**RE: WSU MILPERRA – 2 AND 2A BULLECOURT AVENUE, MILPERRA (SSD-97092958)
 TRAFFIC RESPONSE TO SUBMISSIONS**

This letter provides a response to the submissions from Canterbury Bankstown City Council to the SSD-97092958 in its letter dated 28 January 2026 and Council's pre-DA lodgement advice for a meeting on 5 September 2025 (Pre-DA-31/2025).

Response to Council's Submissions to SSD-97092958 – Traffic (January 2026)

Attachment 1

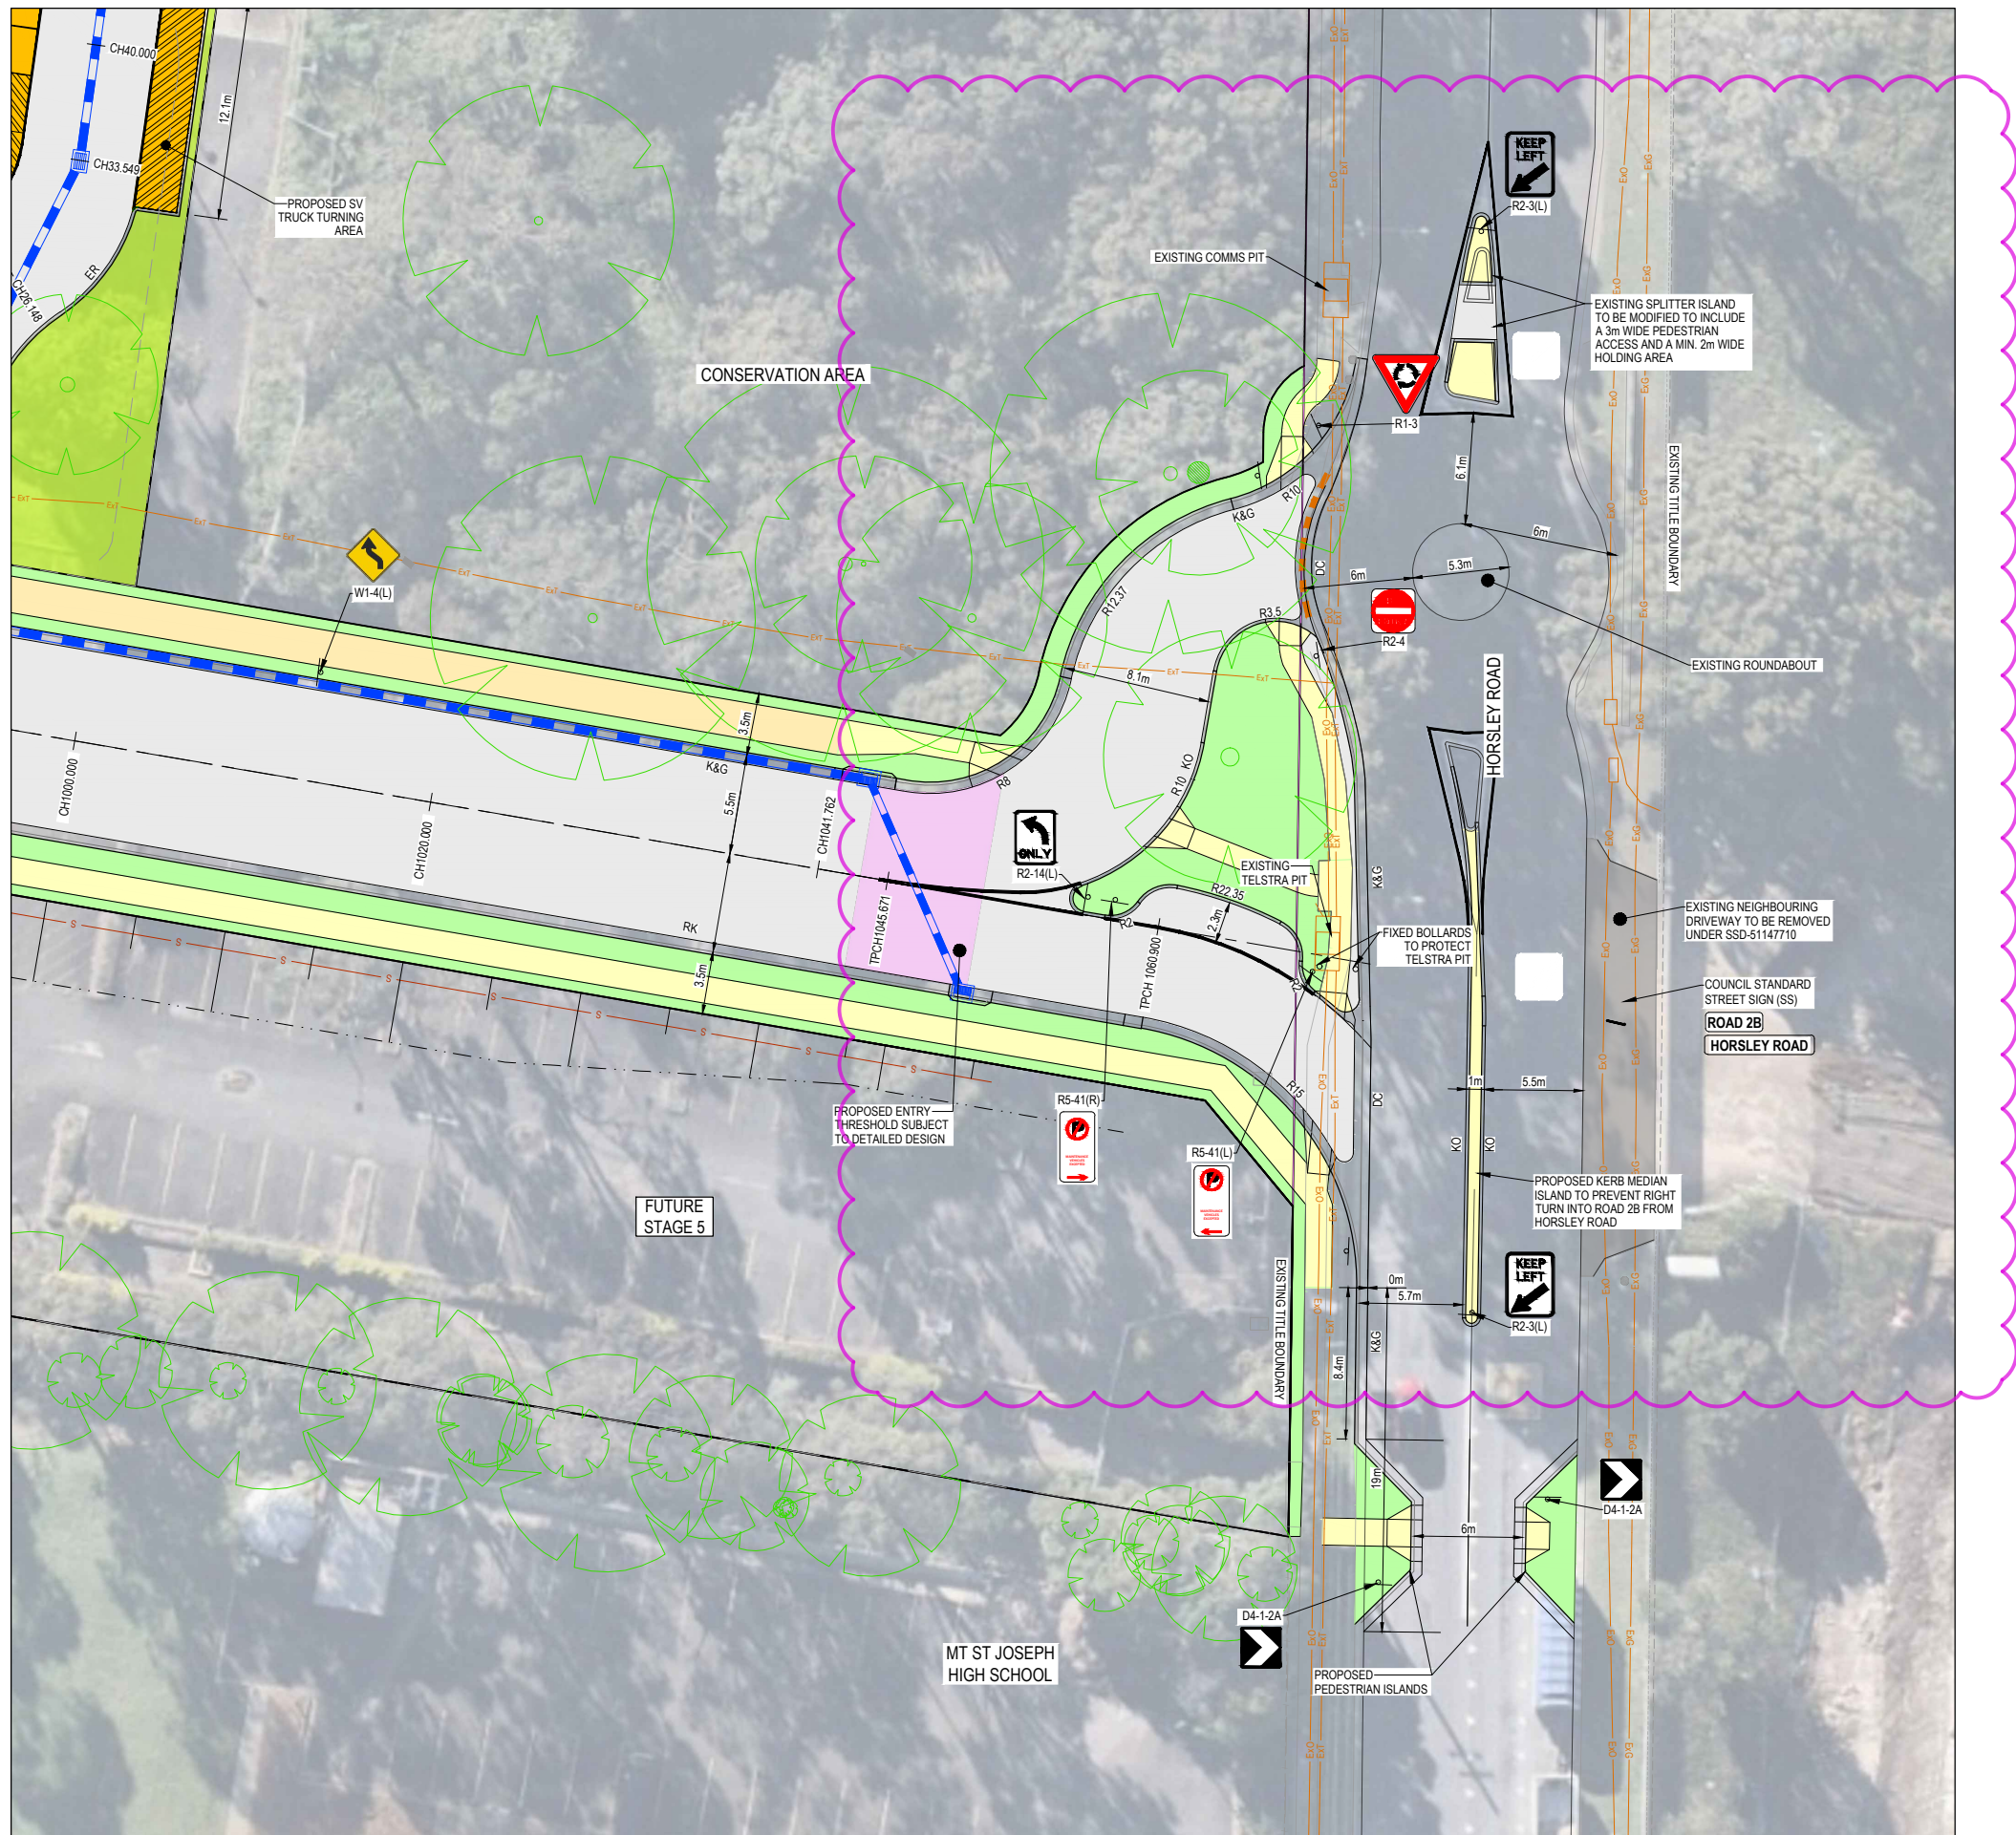
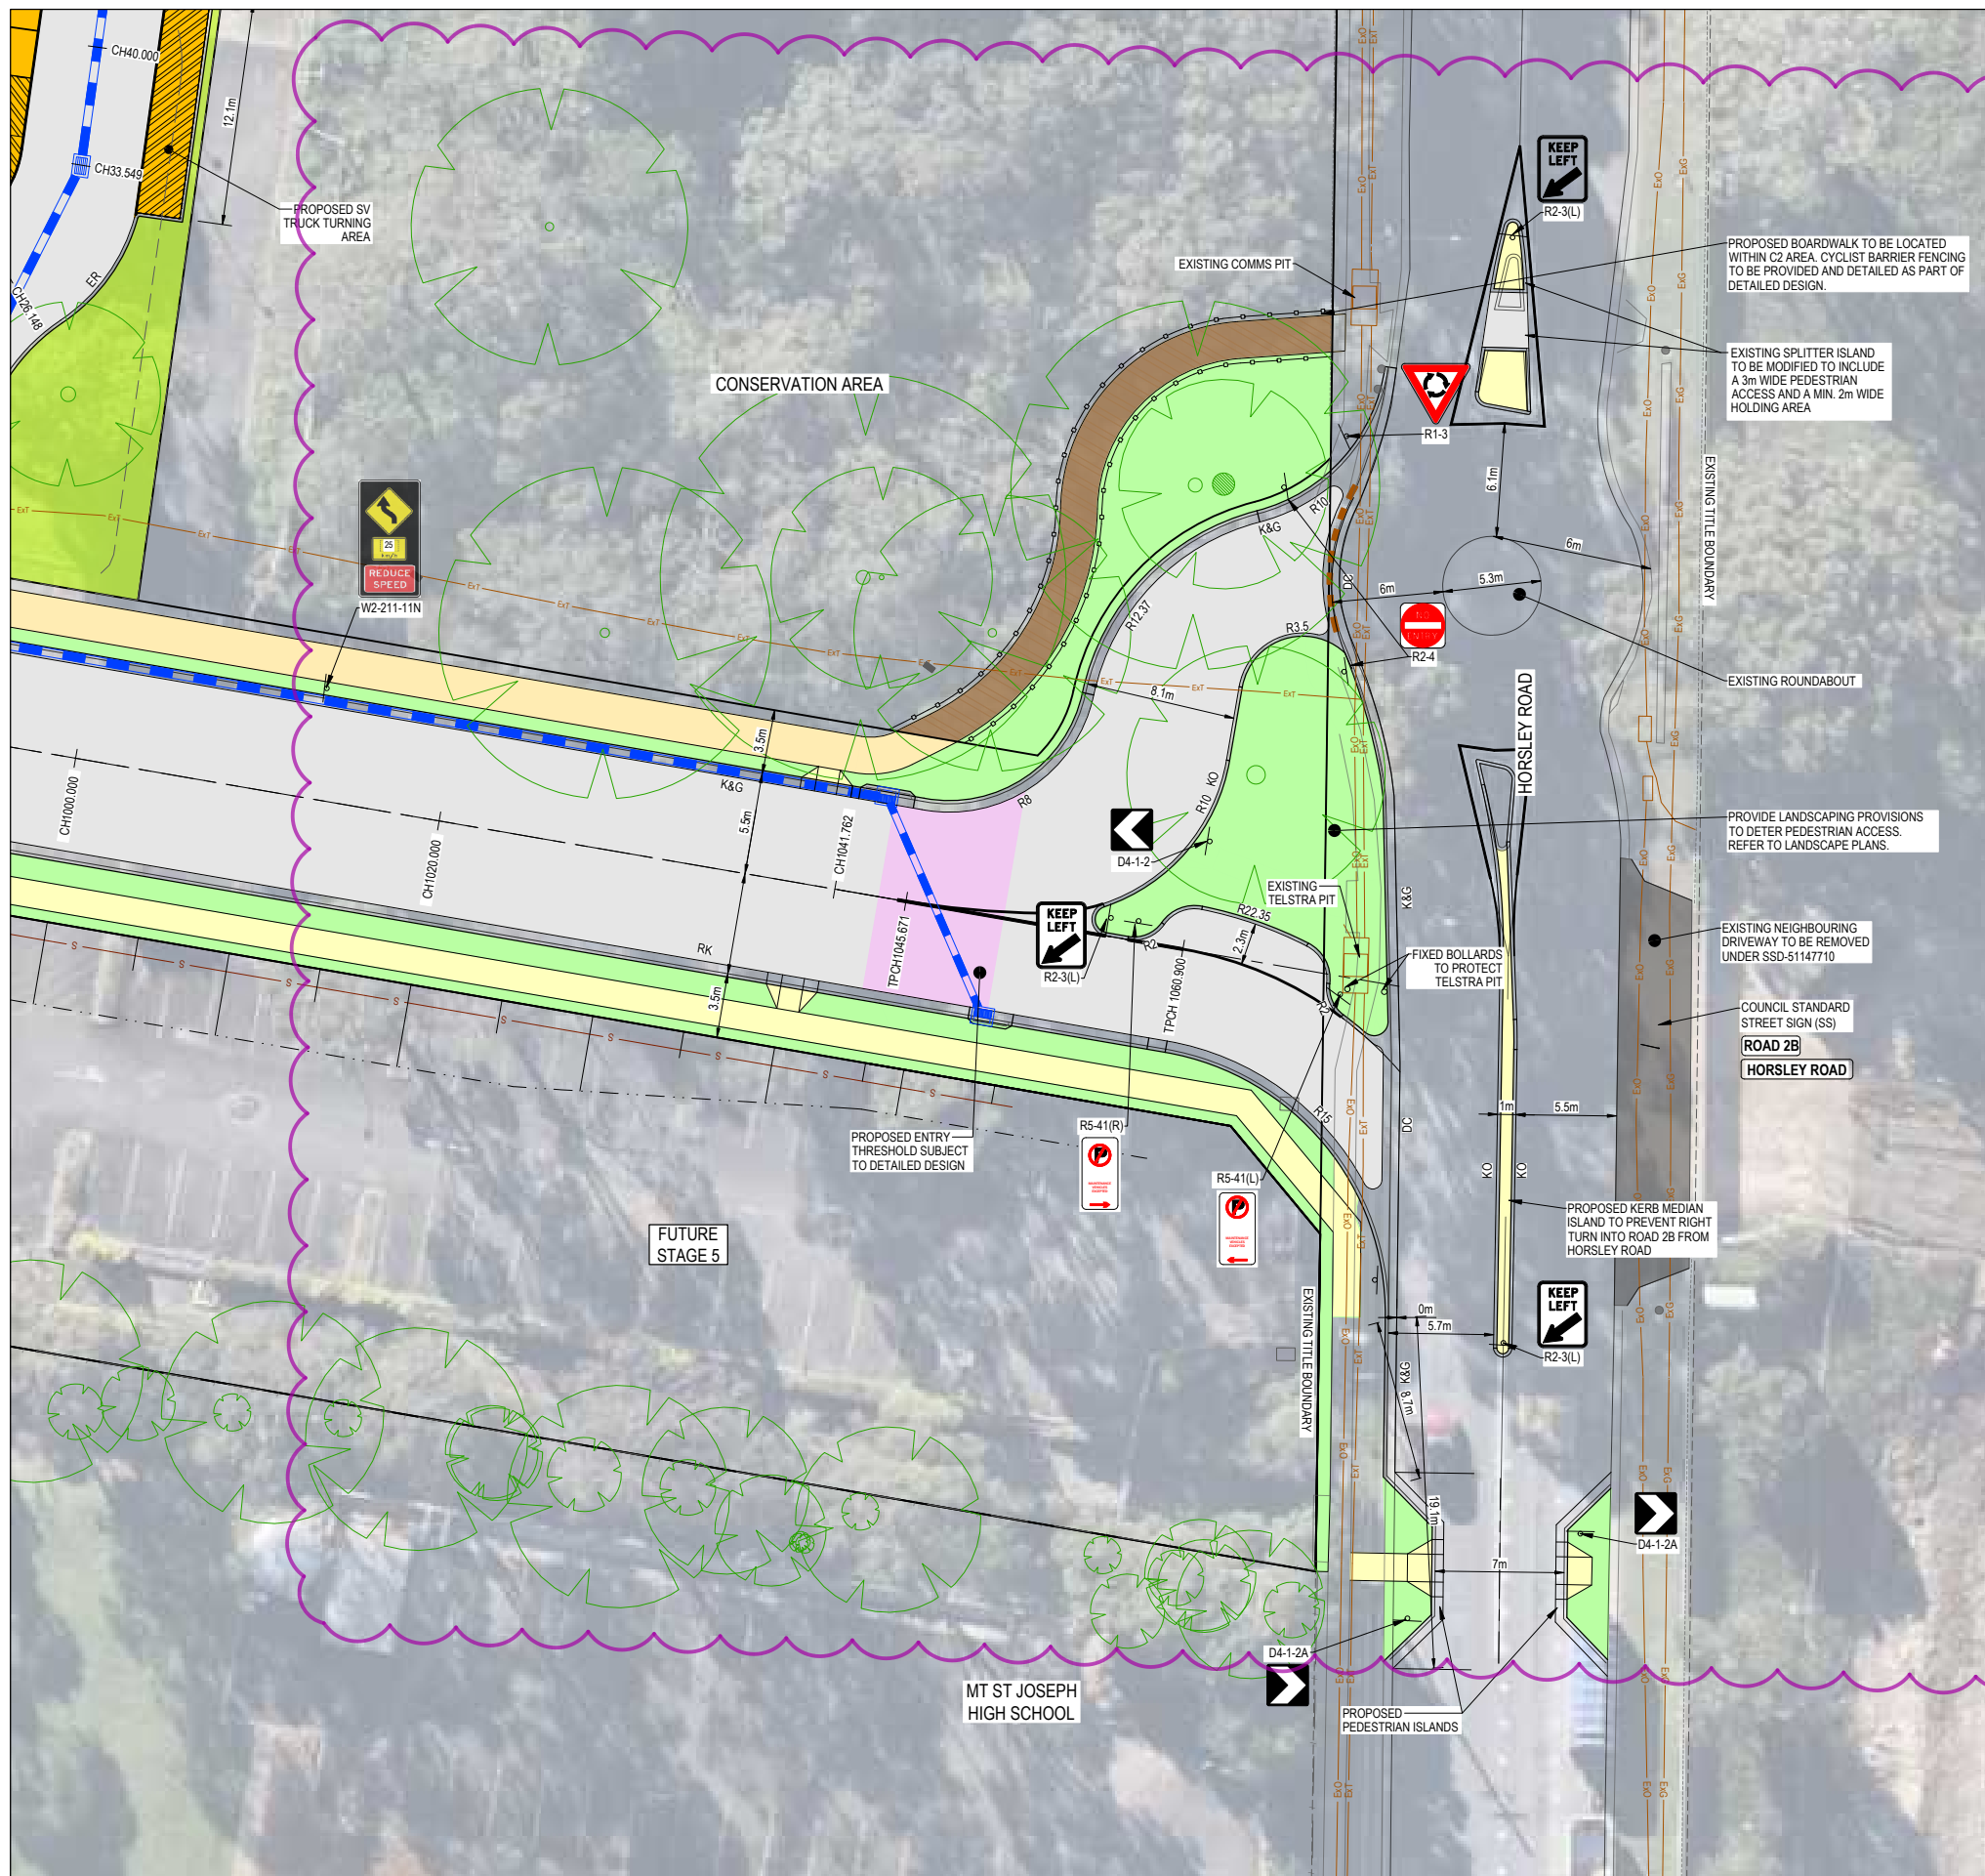
Council's Comments	TPP Response
pedestrian crossing on Road 2A must be proposed 5m to the south of the holding line on Road 2A. It is currently at the holding line and does not allow one car space to queue.

Figure 3.6: Proposed Pedestrian Crossings within Internal Roads  To comply with the condition C7 - Pedestrian crossings must be installed at least 5m away from stop/give way lines to allow one car space., the proposed	The civil plans have been updated to remove the shared environment pedestrian crossing treatments on Road 2A. Alternatively, kerb extensions are proposed on both sides of the road to facilitate pedestrian crossing movements across Road 2A. The proposed kerb extensions provide a shorter crossing distance for pedestrians whilst also acting as a traffic calming device to reduce the travel speed of motorists. Associated signage will be provided to remove any suggestion that this is a crossing where pedestrians have right of way and motorists have priority on the road through those crossing points. Raised thresholds are proposed to the north of the crossing points away from the intersection, to further support reducing the travel speed on the road to ensure pedestrian safety. Landscaping will be provided on both sides of the raised thresholds to indicate those are not crossing points and ensure pedestrians do not cross at those thresholds.

Figure 3.4: Proposed Site Access - Horsley Road

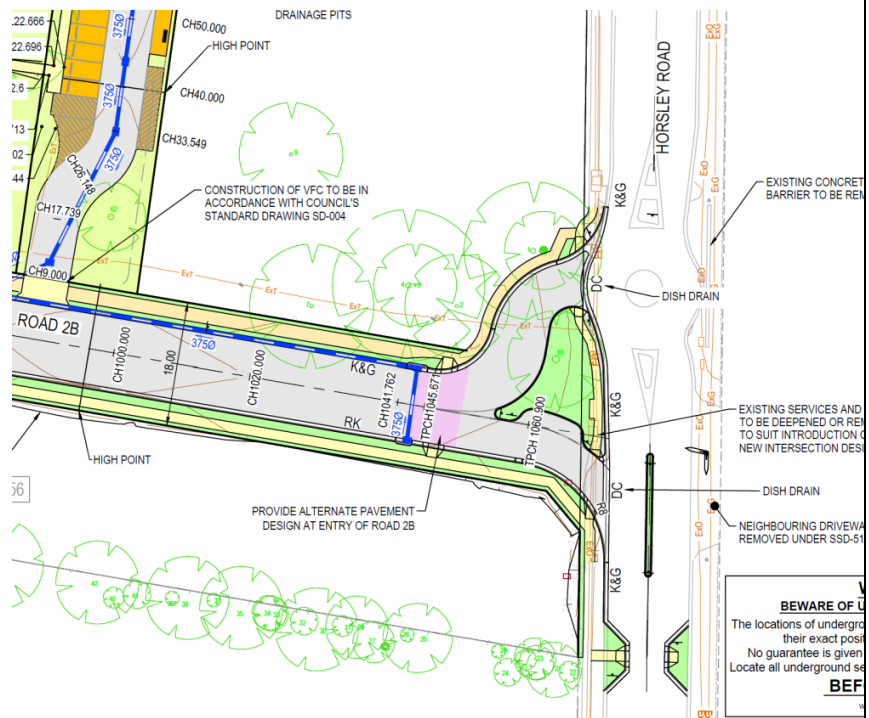
Council's Comments	TTPP Response
Proposed changes to the roundabout access on Horsley Road Figure 3.4: Proposed Site Access - Horsley Road  Source: Beveridge Williams, Layout Plan Stage 3A, Sheet 1 of 2, Drawing No. 054, Rev.C To reinforce the restriction on right-turn movements from Horsley Road into the access road, it is recommended that the gap between the existing roundabout splitter island and the proposed median island (located between the left-in access and the southern kerb extension) be filled. This treatment will physically deter and prevent illegal right-turn movements into the access road. It is also recommended that the Applicant reconstruct the northern splitter island to bring the roundabout up to current standards with respect to pedestrian refuge width. The existing pedestrian gap measures approximately 1.68 metres, whereas current standards require a minimum width of 3.0 metres. It is acknowledged that upgrading the southern splitter island to incorporate a pedestrian gap may inadvertently encourage motorists to utilise this gap to perform a prohibited right-turn movement from Horsley Road into the access road. Accordingly, it is acceptable for the Applicant to instead provide a raised pedestrian crossing, kerb extension, or slow point further south of the access driveway on Horsley Road, as shown in Figure 3.4, to improve pedestrian safety without compromising the proposed traffic restrictions.	The design of the roundabout access on Horsley Road has been updated in accordance with Council's comments. The civil plans have been updated to extend the existing splitter island to the south of the roundabout to connect with the proposed median island, to ensure right-turn movements into the site are restricted. Widening of the pedestrian refuge on the northern splitter island has been adopted to provide a standard minimum refuge width of 3m.
